**Consultation Response from KC,
Lead Local Flood Authority****2020/93954 Land at, Lingards Road, Slaithwaite, Huddersfield, HD7 5HY****Erection of 43 dwellings and associated works****Date Responded: 16th November 2022****Responding Officer: Paul Farndale****Responding Ref:**

Detail
ROAD & SEWER FEASIBILITY PLAN

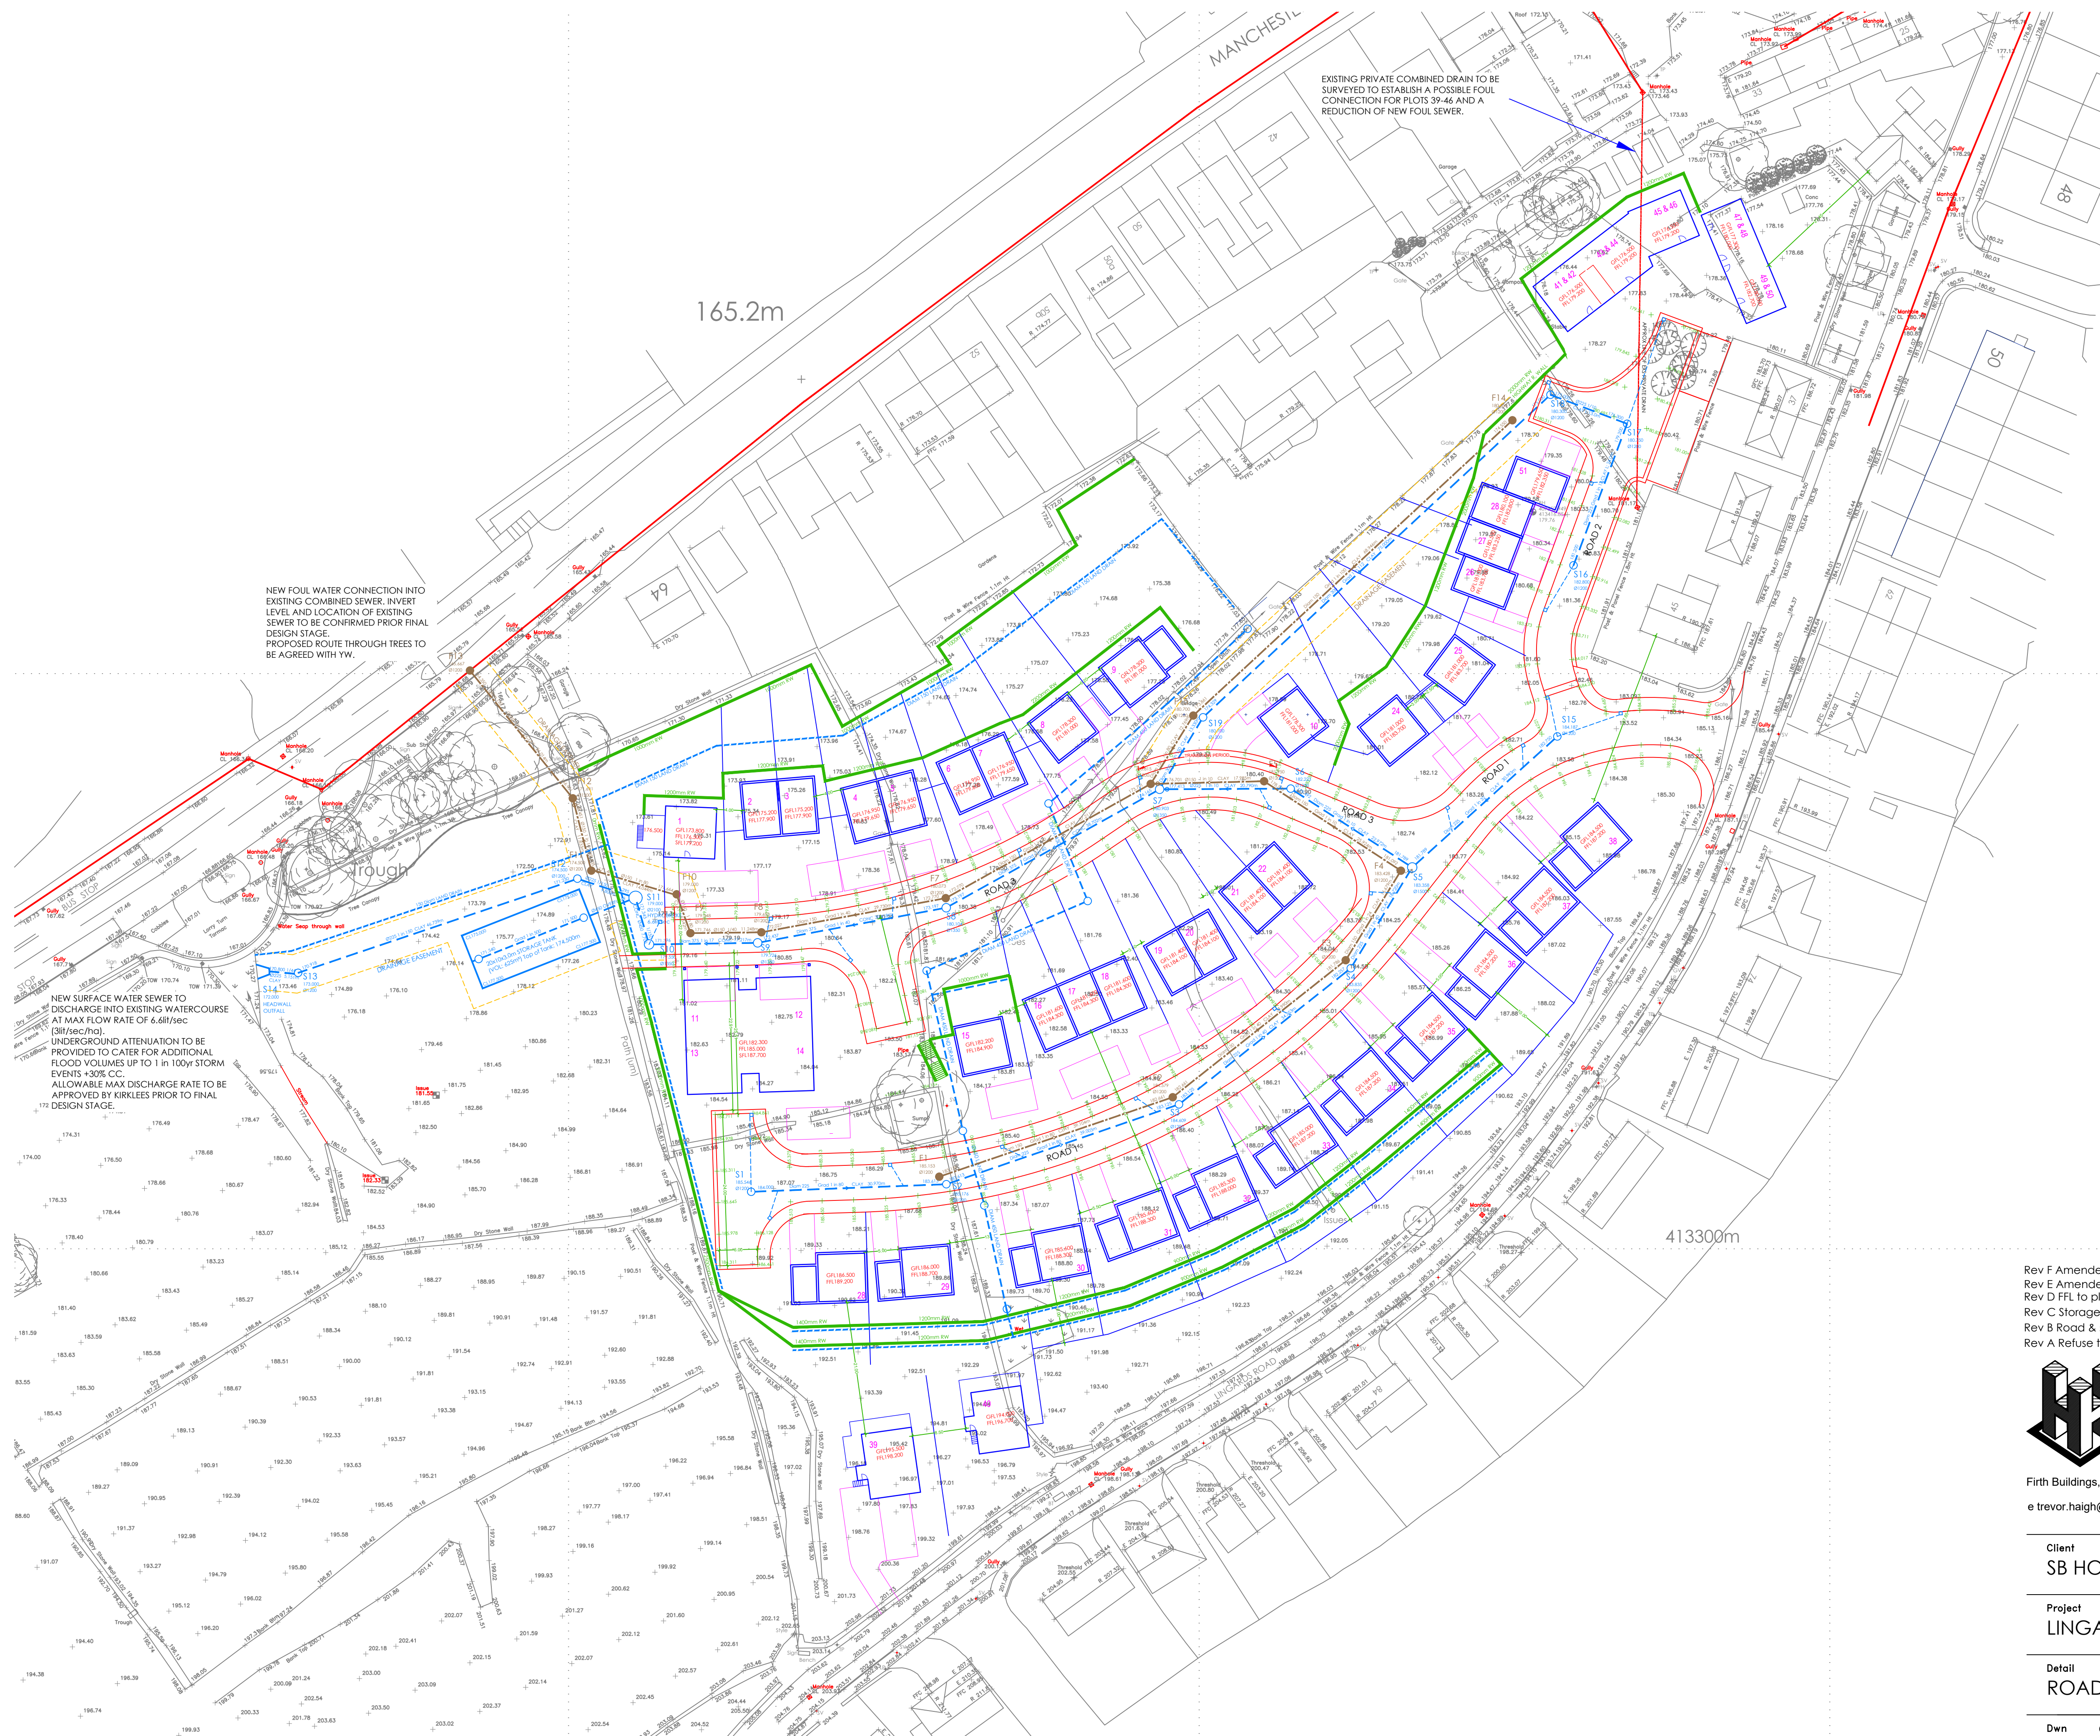
Kirklees LLFA would object to any pumped discharge of surface water. Current plans adhere to this stance.

Due to restrictions identified on the man-made watercourse crossing site from west to east, no connections of roof or road surface water should be made to this system, only land drainage renewal. Current plans adhere to this principle.

For the site to be drained by gravity, Kirklees LLFA does not object to a connection to public combined sewer for all plots than cannot provide a gravity to connection to agreed watercourse outfalls.

In reviewing discharge rates for the site, a 5l/s to local systems that ultimately connect to the river Colne can be increased to for the 1 in 100 year + 30% climate change critical storm event, (currently suggested as 6.6l/s in the submitted flood risk assessment). However, this is on the agreement that an LLFA instruction to renew an upsize 130mm x 220mm stone culvert identified in land to the west of the site to a yet to be agreed connection point in Manchester Road. **This verbal agreement has not translated onto plan and the LLFA OBJECTS to the application on the basis that off-site improvement are necessary to reduce risk posed by the increased volume of surface water dependent on this outfall.**

perimeter land drain is shown but not connected as an overflow. It is also shown as 150mm which would be considered inadequate. Further assessment is required.
